Re: PA23-026 – Cornelius Lacey PRD – Technical Review 2

BINDING SITE PLAN / PLANNED RESIDENTIAL DEVELOPMENT COMMENTS

TO: Amy Hess – Senior Planner
FROM: Jesse Hannahs, P.E. – Traffic Engineering Manager
DATE: February 28, 2024
SUBJECT: PA 23-026 – Cornelius Lacey PRD

HORIZONTAL CONTROL PLAN
MARYSVILLE WASHINGTON

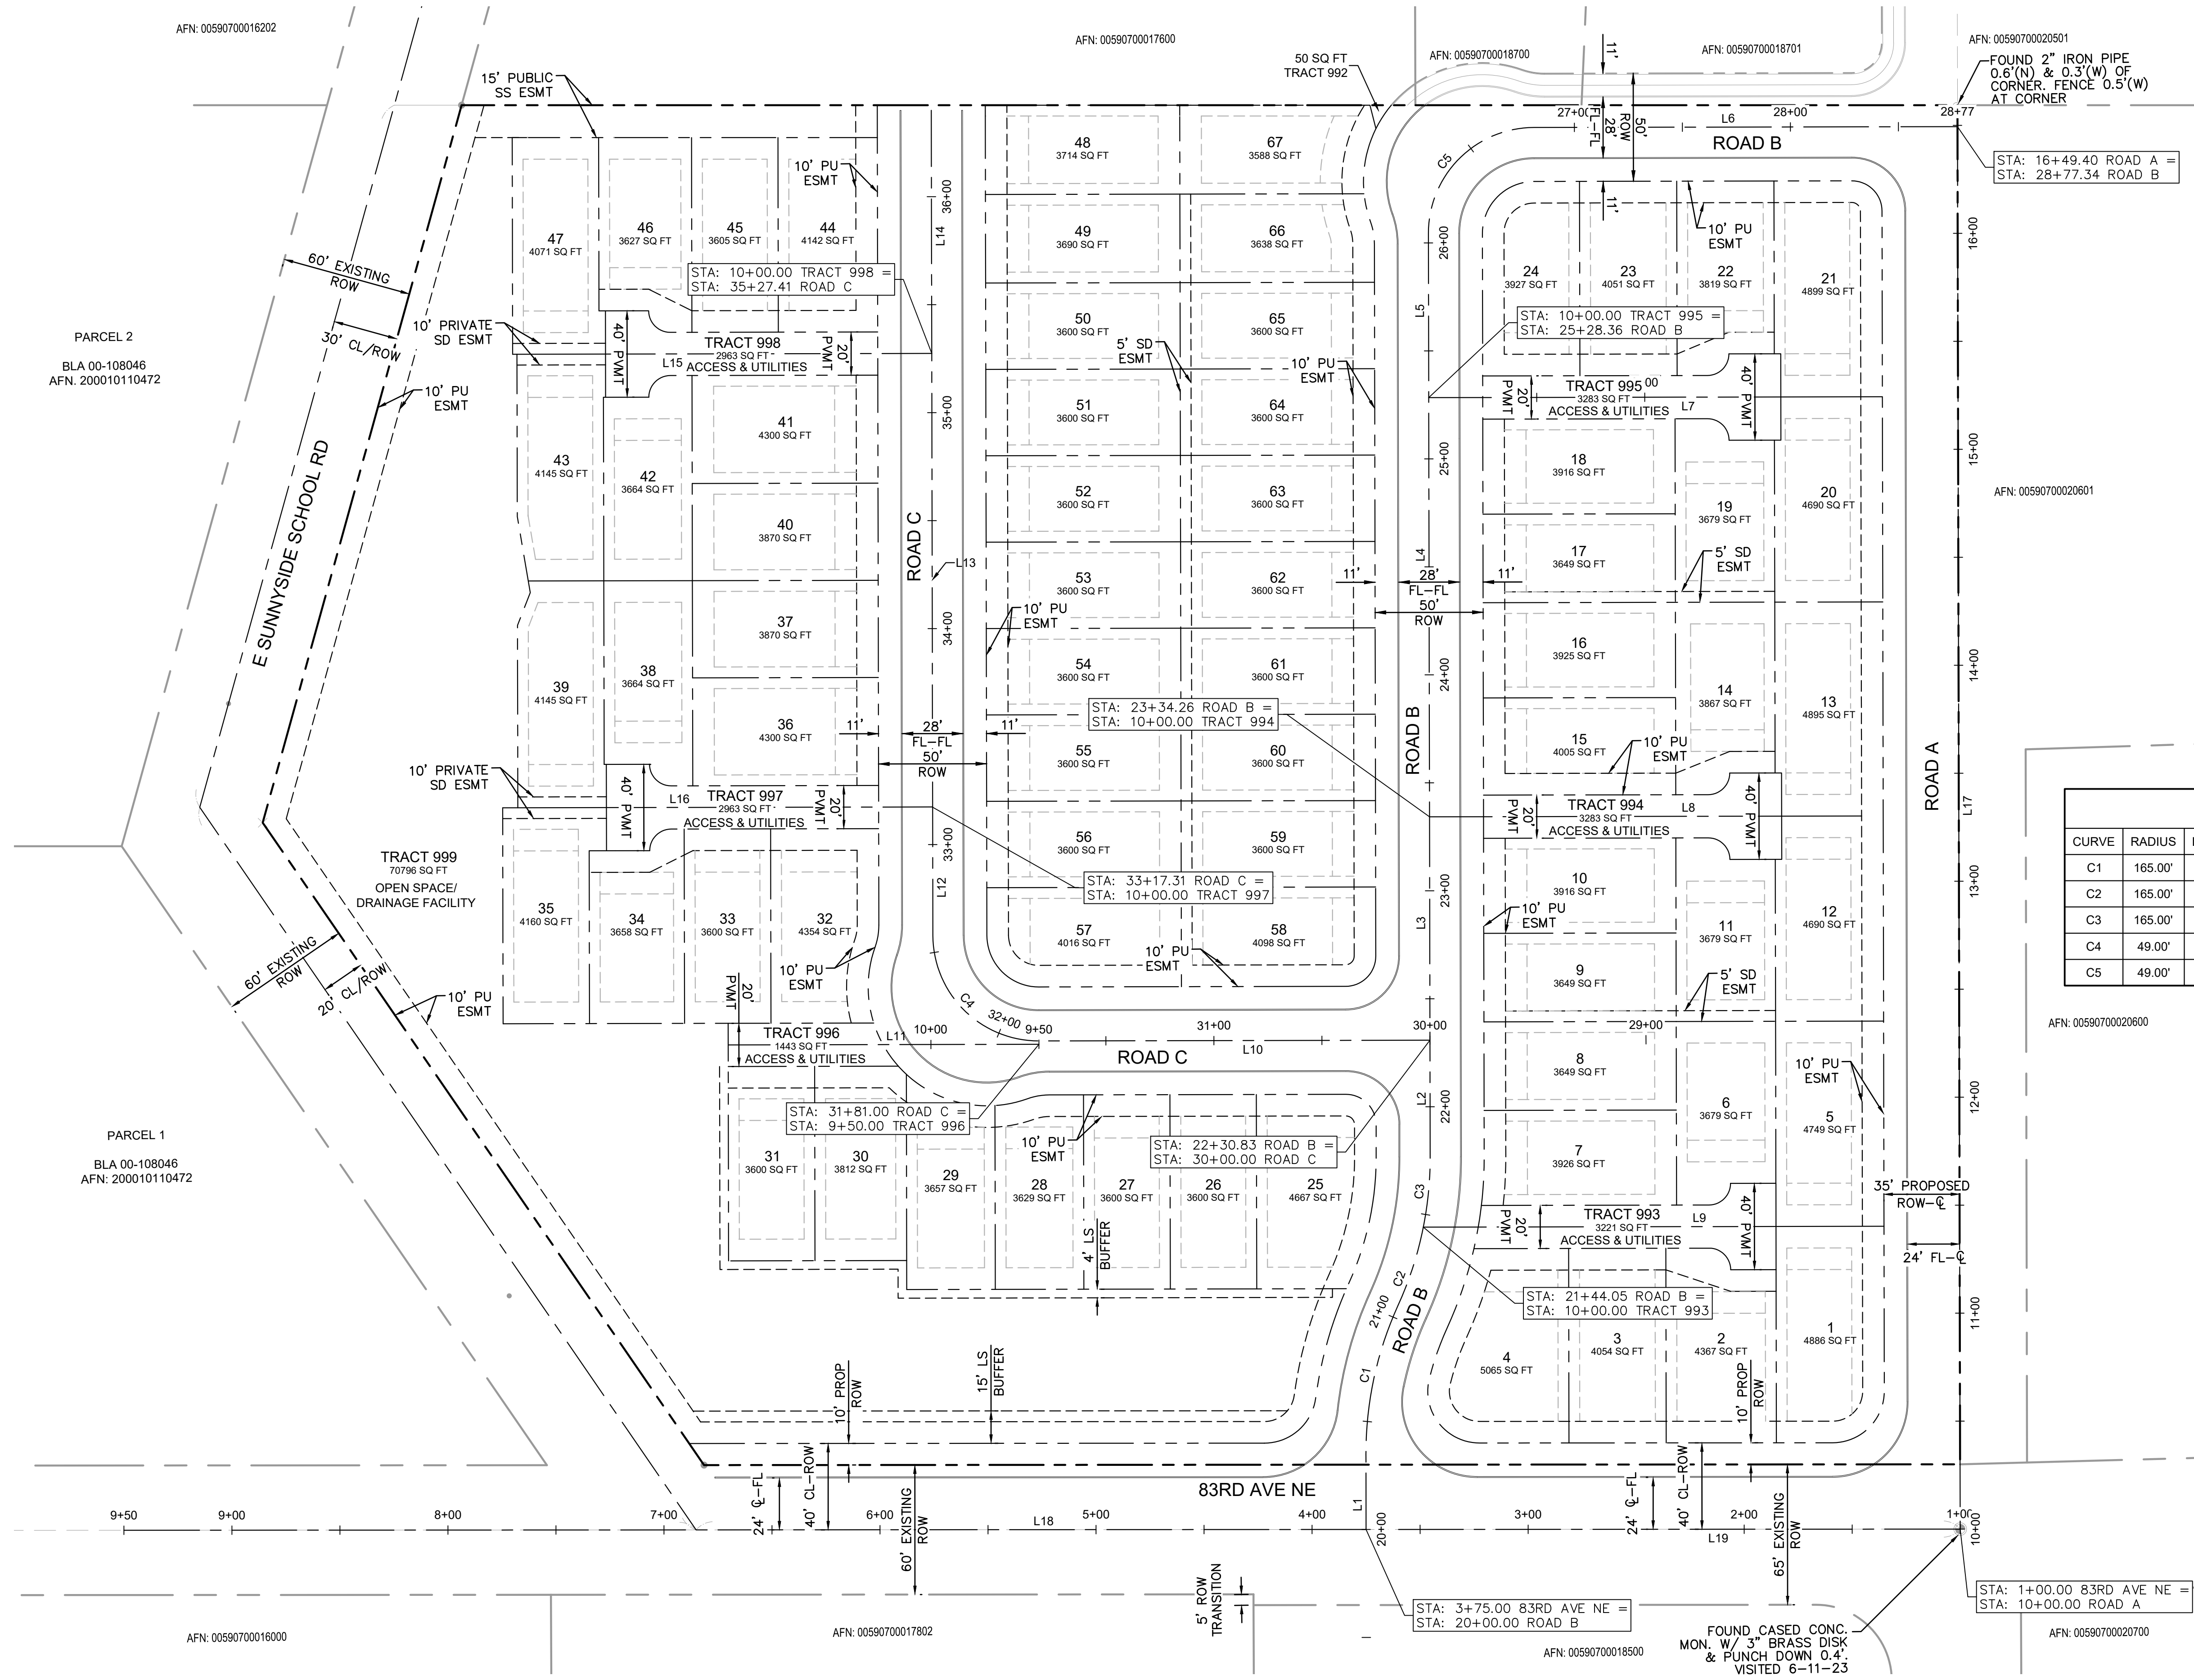
- ii. ROW shall be provided on the Northeast corner of intersection of 83rd Ave NE & 44th ST NBE to enable potential for future traffic signal installation.

- 1. Suggested ROW shall be recommended as 5' behind sidewalk around radius from outside extent of curb ramps.
- 5) Per EDDS 3-506, street lighting will be required.

DRAWING TITLE:
LANDSCAPE PLAN
APPLICANT:
KM CAPITAL, LLC
C/O LAND PRO GROUP INC.
10515 20TH STREET SE, SUITE 202
LAKE STEVENS, WA 98258
(425) 231-2718

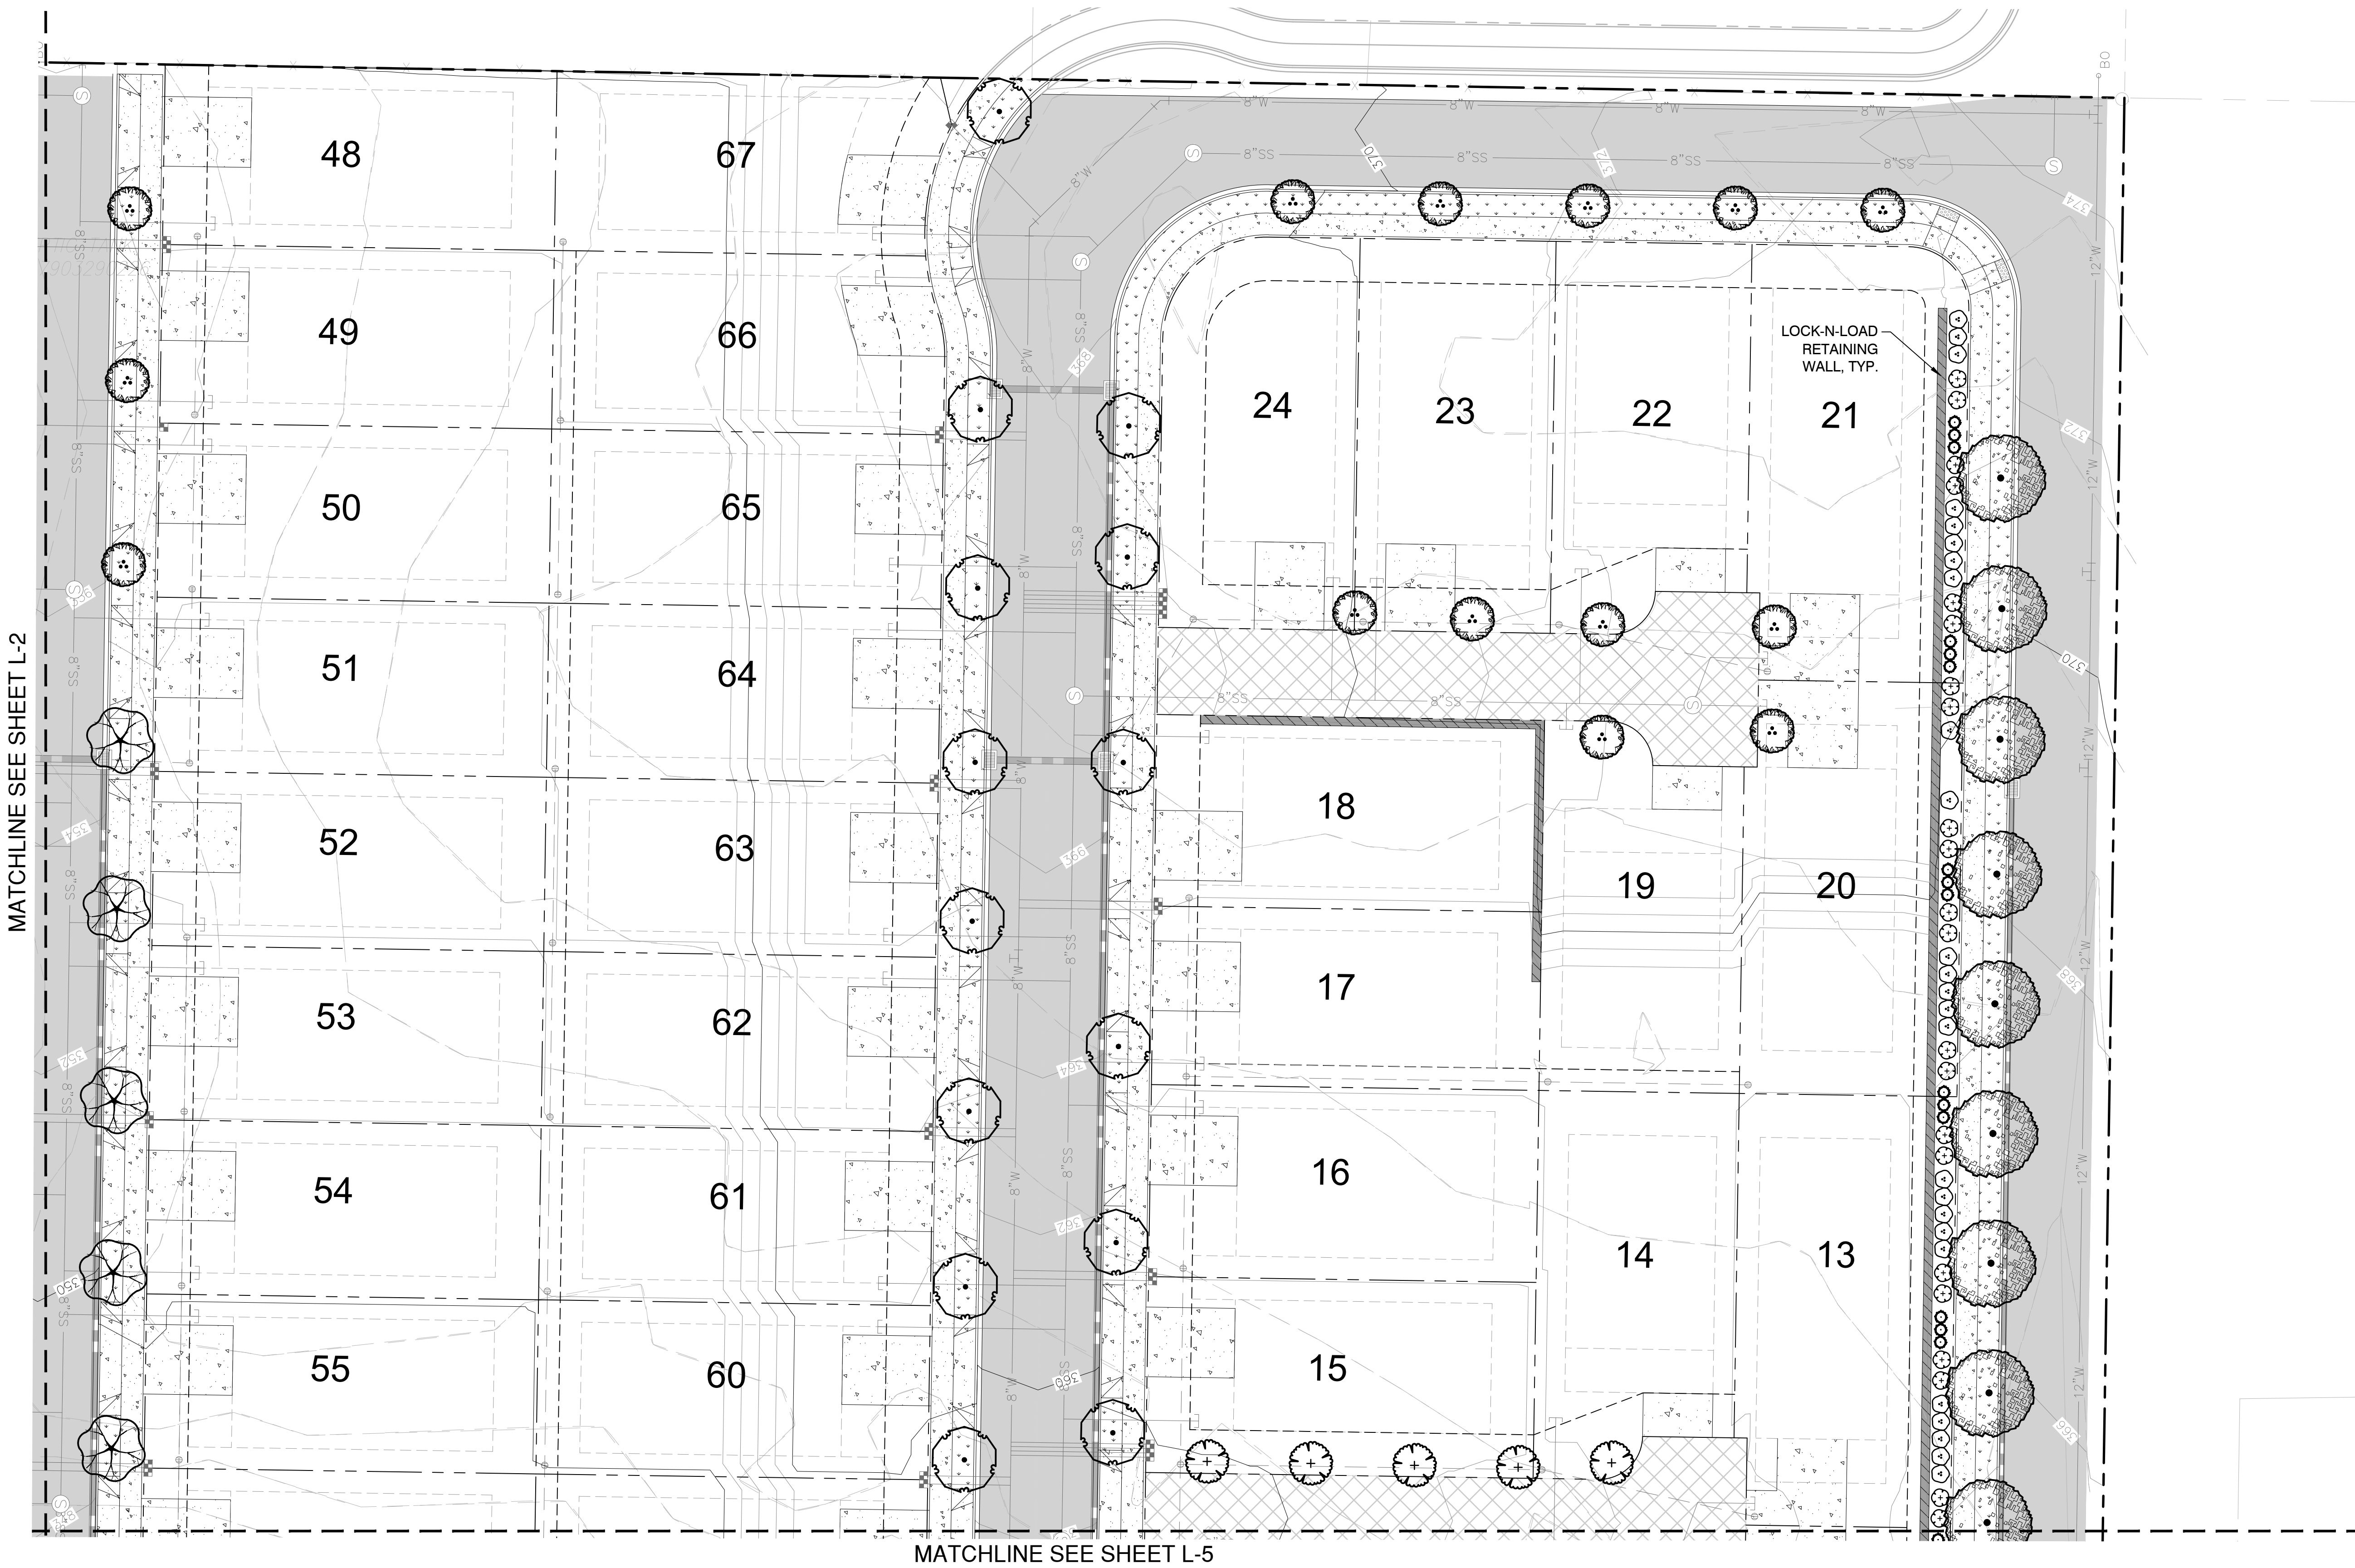
3. In development configurations where side yards abut a street, fences taller than 3-1/2 feet shall be setback at least 5 feet from the sidewalk to allow for landscaping to soften the view of the fence. Provisions for long-term maintenance of this landscaping shall be addressed on the plat. **Additional landscaping is needed along the wall on the southern portion of lot 25.**
